EROSION AND STORMWATER QUALITY CONTROL PERMIT (ESQCP) EL PASO COUNTY APPLICATION AND PERMIT PUDSP215 & SF237

Project Information	
Project Name	Waterbury Filing No. 1
Legal Description	See attached
Address (or nearest major cross streets)	Stapleton Drive and Bandanero Drive
Acreage (total and disturbed)	Total: 61.87 acres Disturbed: 73.45 acres
Schedule	Start of Construction: Summer 2025 Completion of Construction: Winter 2025 Final Stabilization: Spring 2026
Project Purpose	Develop 198 single family homes
Description of Project	Construct 198 single family homes with roadways, supporting utility infrastructure and and? elaborated
Tax Schedule Number	4200000417, 4200000366

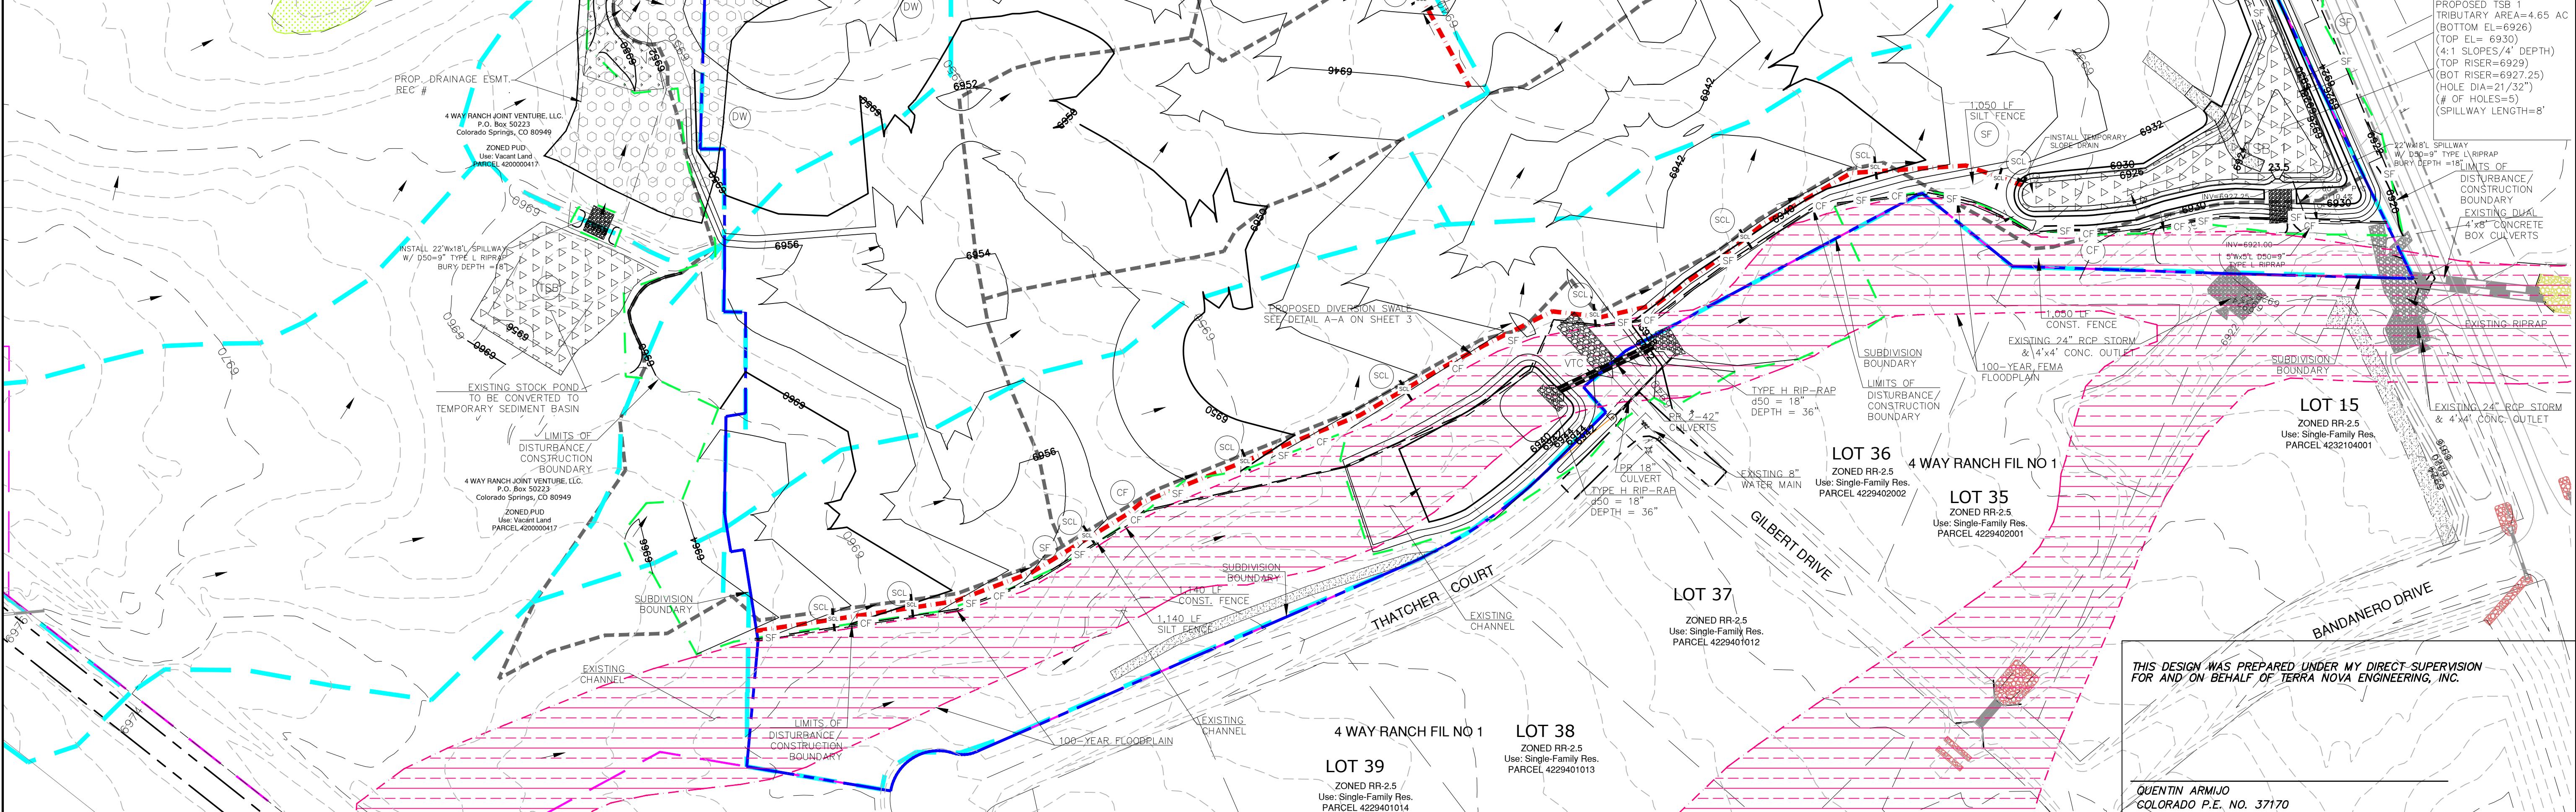
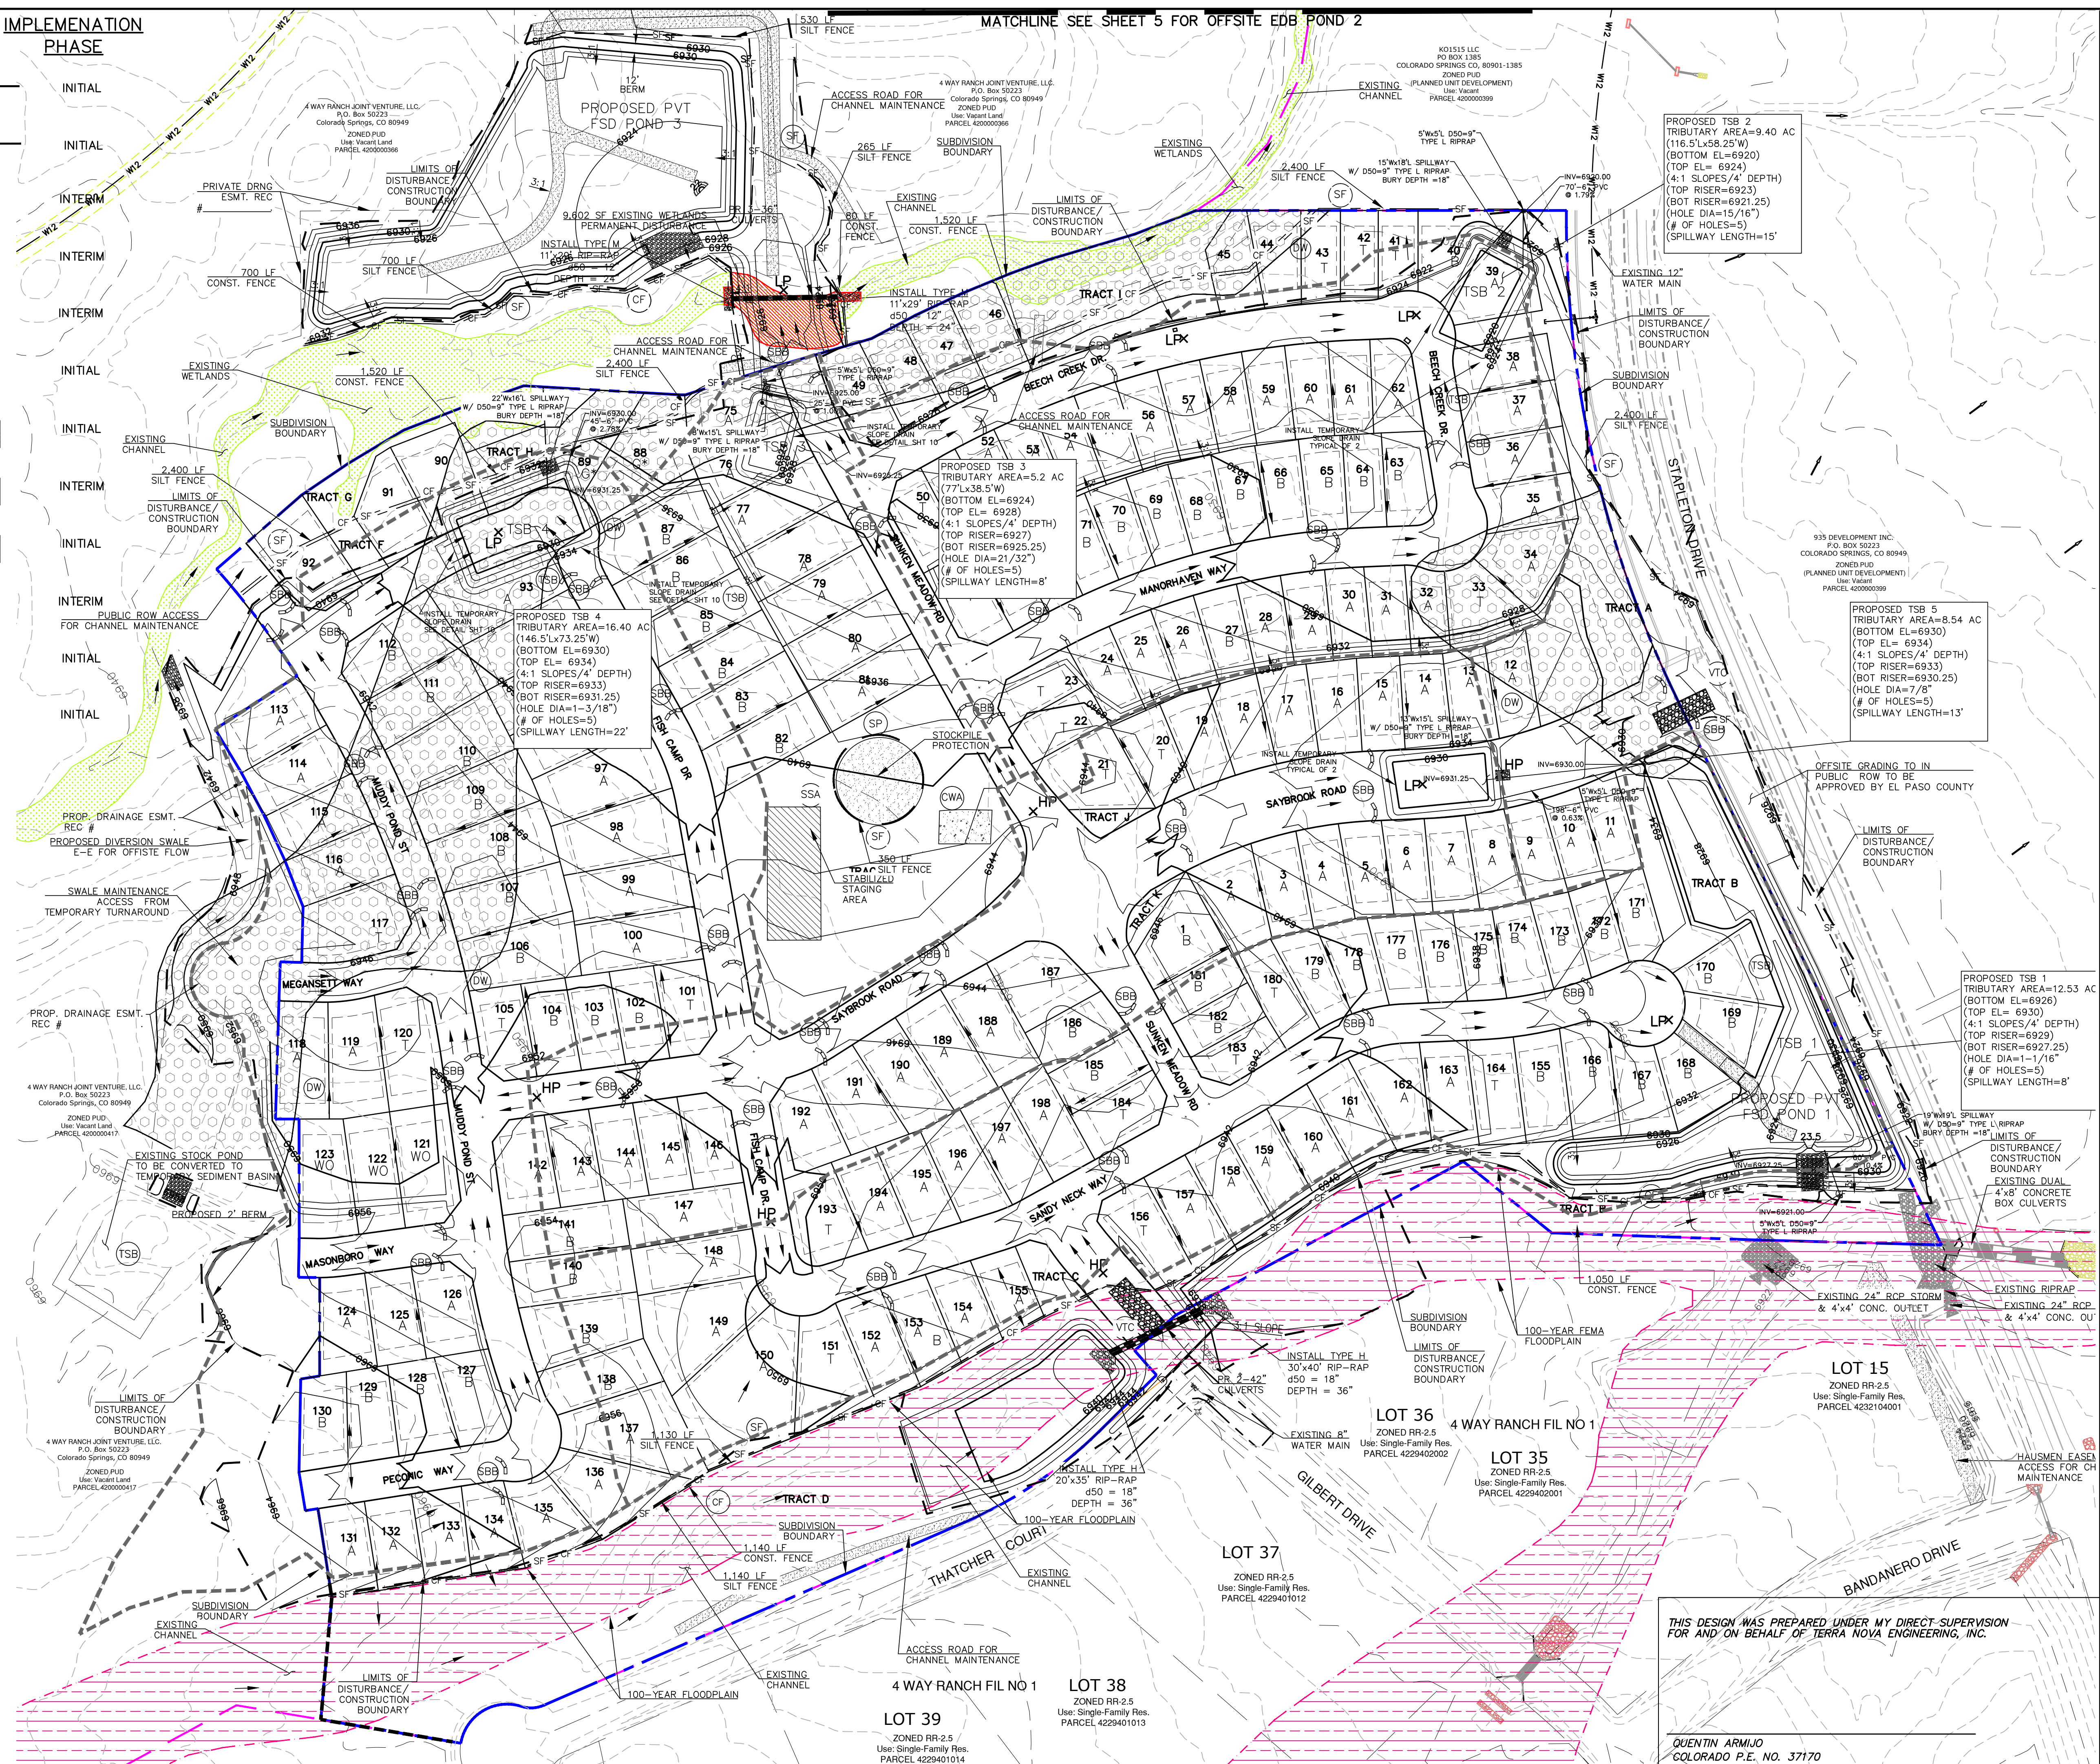
Unresolved: GEC Plan sheet 3 states 69 ac. This value should match the GEC Plan and SWMP.

updated GEC sheet 3 to 73.45
